RE: Fielder Variance Application (VA-20-00014) – Deemed Incomplete

Parcel # 486835

Kittitas County Community Development Services received an Administrative Setback Variance request on December 14, 2020 to reduce the required setback from the west front lot line from 25' to 2'4" for a detached garage. The subject property is zoned Forest & Range. This parcel (486835) is located off of Via Kachess Rd in Easton, WA and bears Assessor's map number 21-13-17051-0022. Your application has been determined **incomplete** as of January 11, 2021.

① Site
 1" = 20'-0"

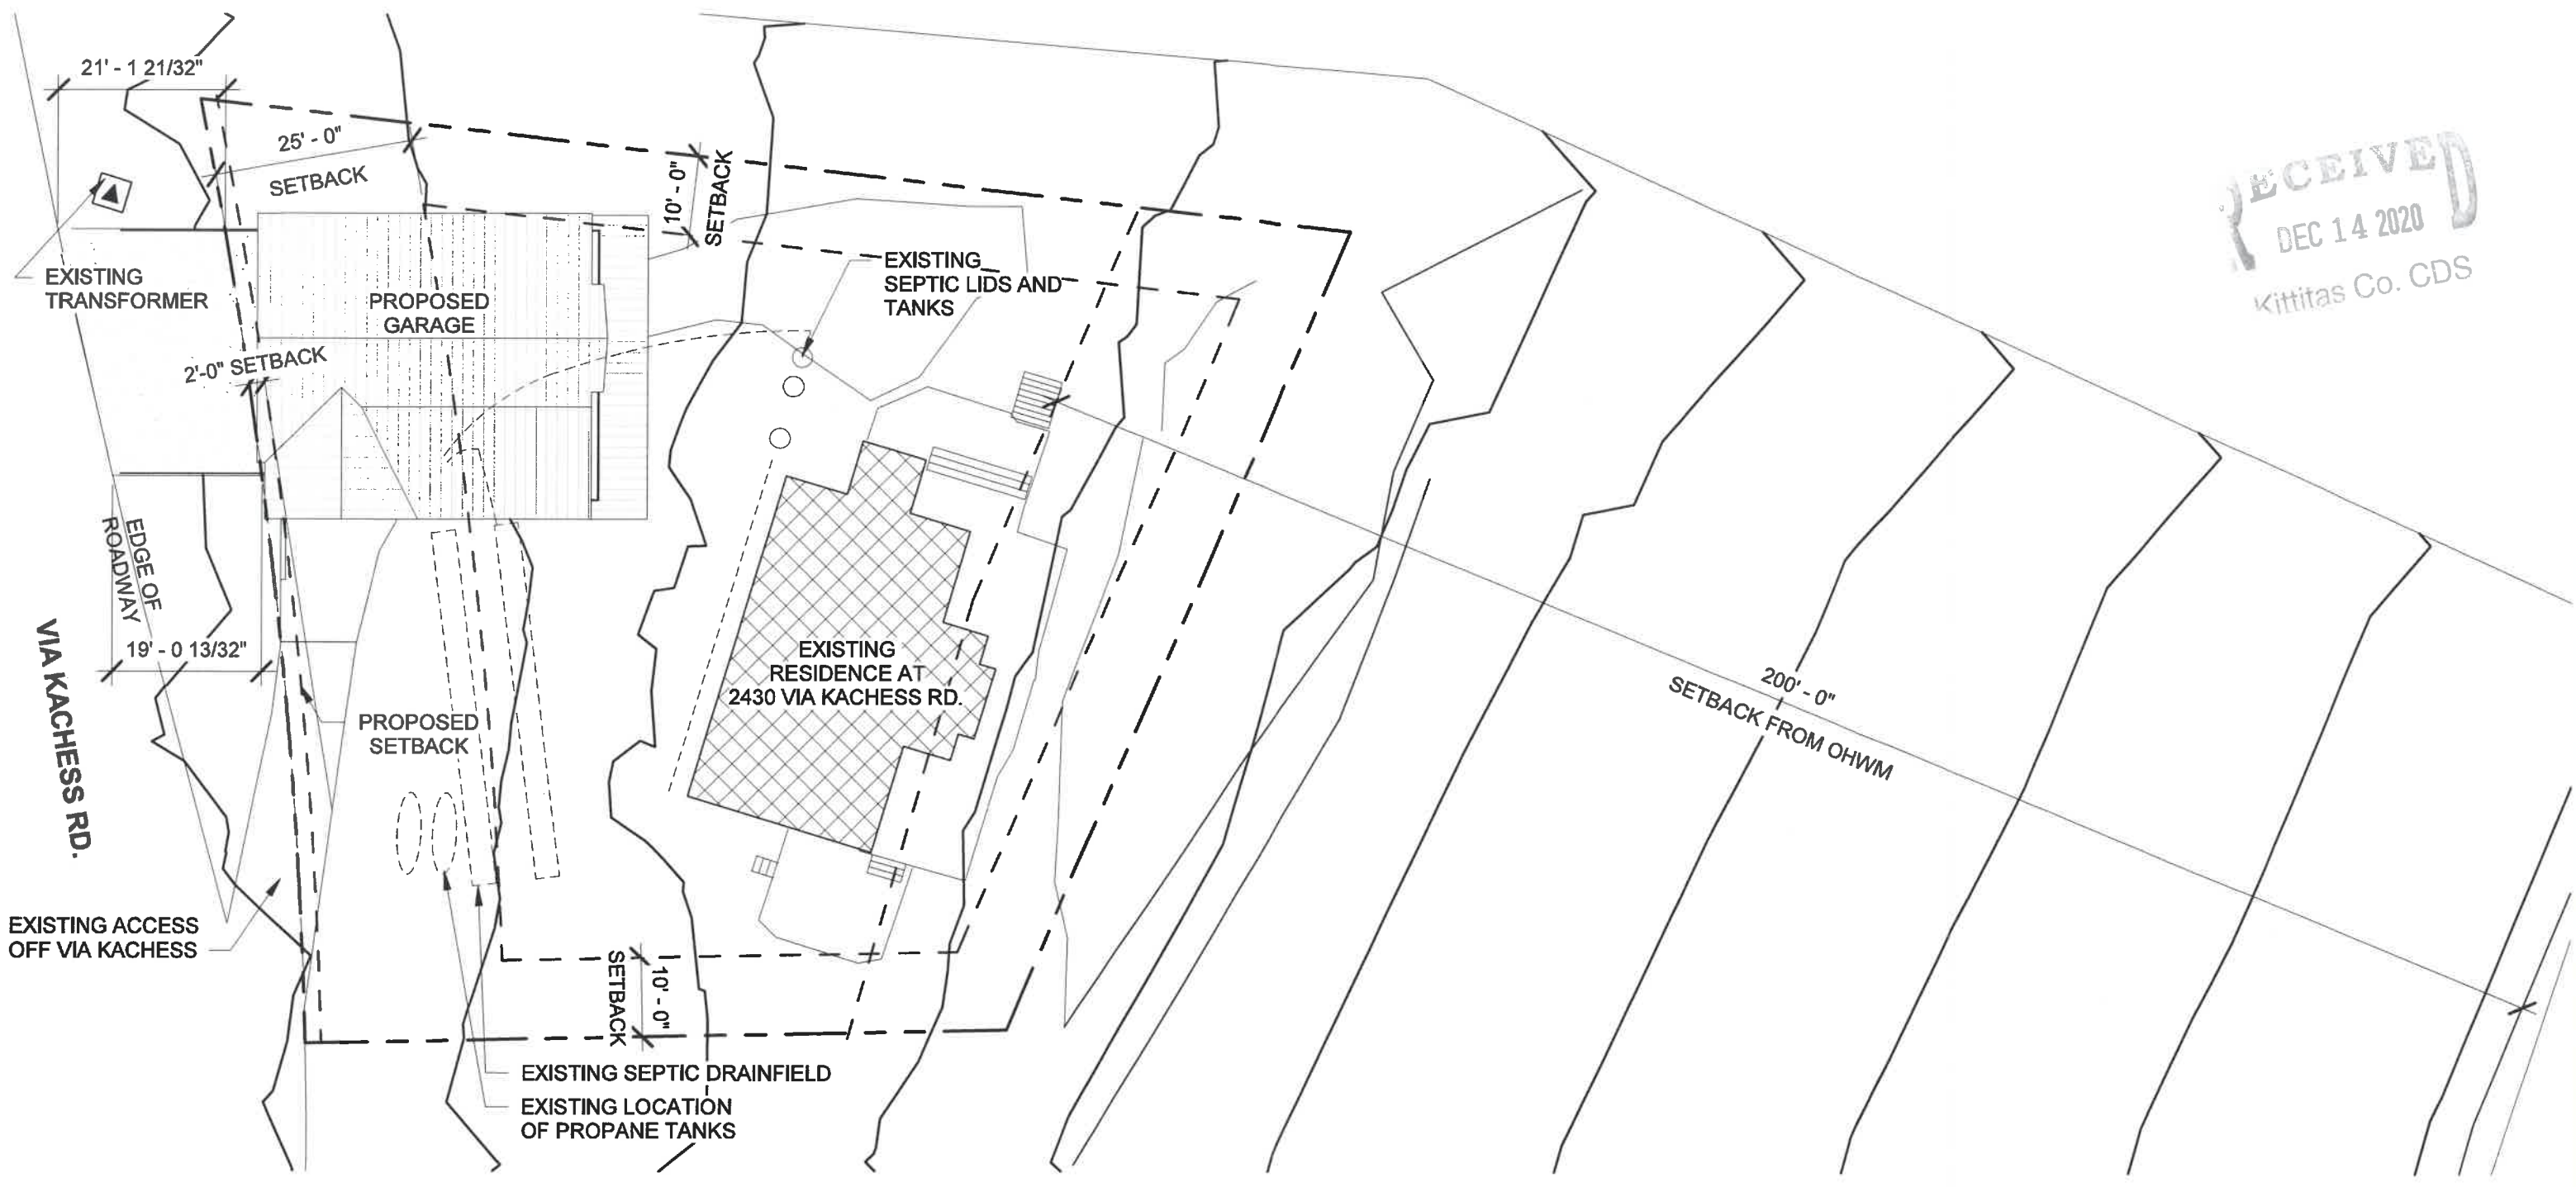
After a review of your application materials, it appears that there is a major discrepancy between the Ordinary High Water Mark (OHWM) measurement on your site plan and the satellite imagery measurement from Kittitas County's mapping software: Compass. Please note that shoreline jurisdiction measurements are horizontal and do not include vertical topographic increases.

Please advise how you determined your OHWM measurement. CDS will continue processing your application once this issue is resolved.
